Application No: AB/135/20/OUT
Site Address: Land at Ford Road Arundel
Description of works: Outline application with some matters reserved (except for access) for the development of 90 dwellings & associated amenity land. This application is a Departure from the Development Plan, affects the setting of listed buildings & affects the character & appearance of the Arundel Conservation Area.

Thank you for your internet representation made on 28th January 2021 which has been recorded as an objection with the comments as follows:

Parameter Plan - Movement

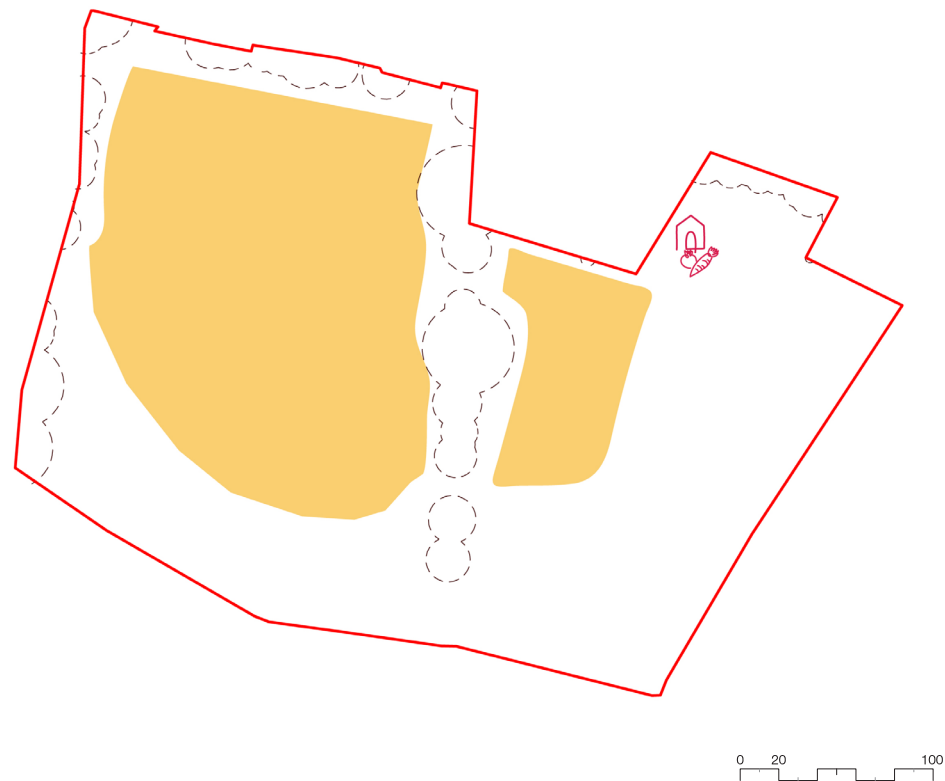
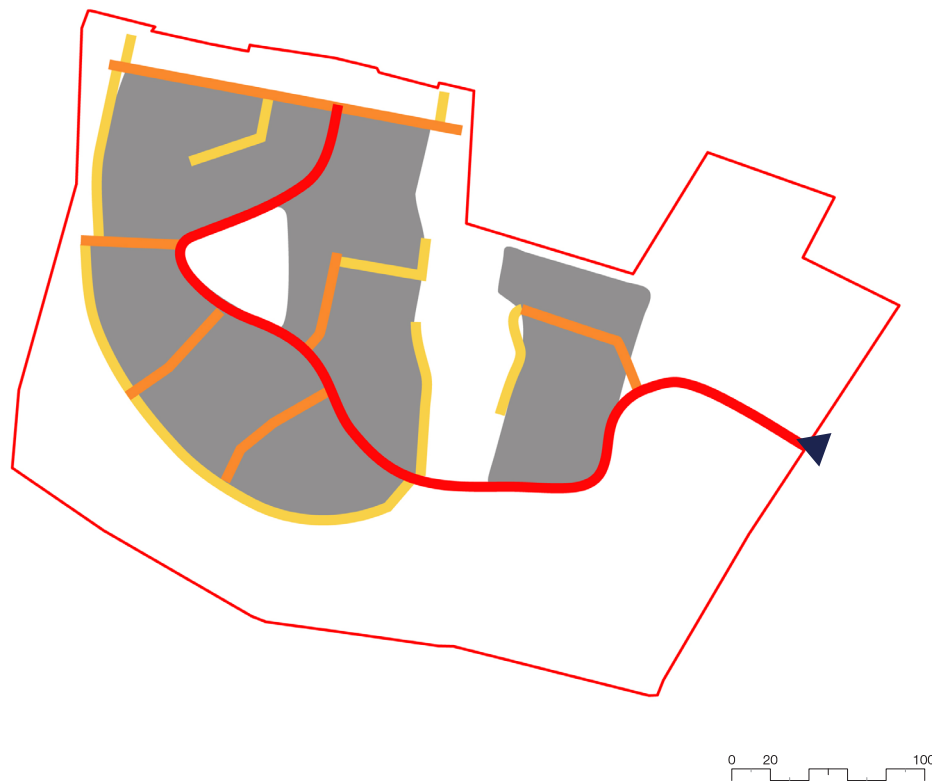
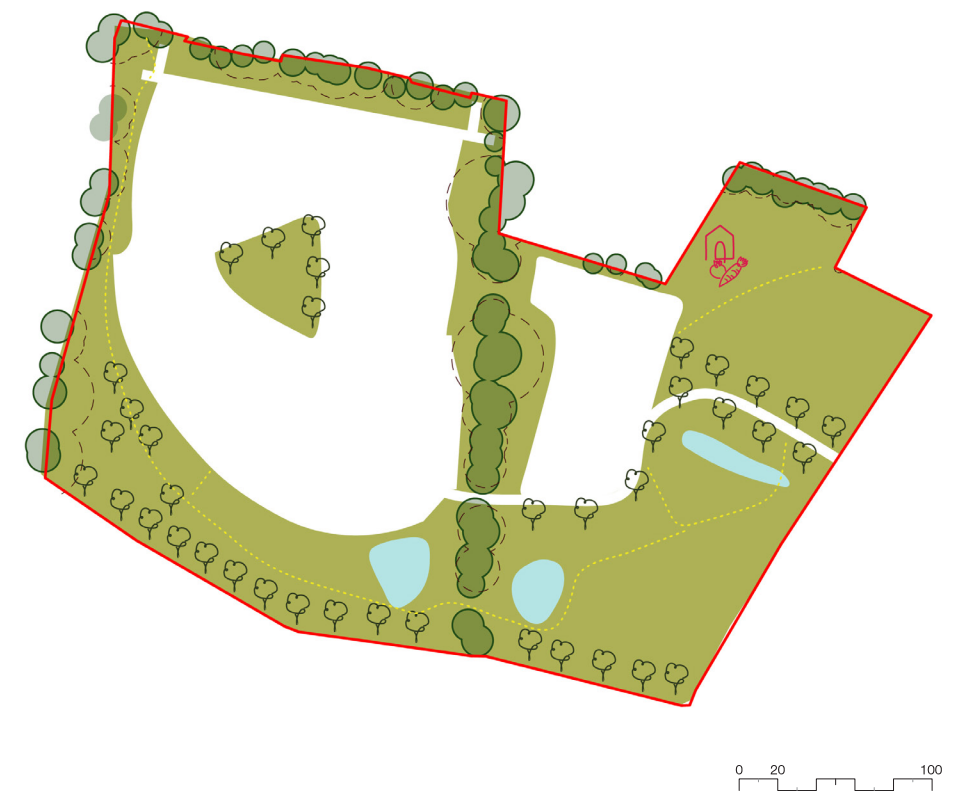
After review of the planning application I am struck by some of the changes made since the original consultation, in particular access from Dalloway Road. We were assured at consultation that this entry into the site would be reserved for emergency vehicle access only. I note that on the revised plans, this is no longer the case. Torton Hill, Dalloway and roads leading to them are quiet roads with little traffic. Our children enjoy playing and riding bicycles in these streets. Opening the site to through traffic will not only increase traffic by the dwellers of 90 new homes, but will create another rat run in Arundel as Ford road becomes busier. This will entirely change the nature of our locality and impact quality of life for all the residents of the surrounding, existing roads. Has any impact assessment been done on this?
I strongly object to the non emergency access from Dalloway Road.
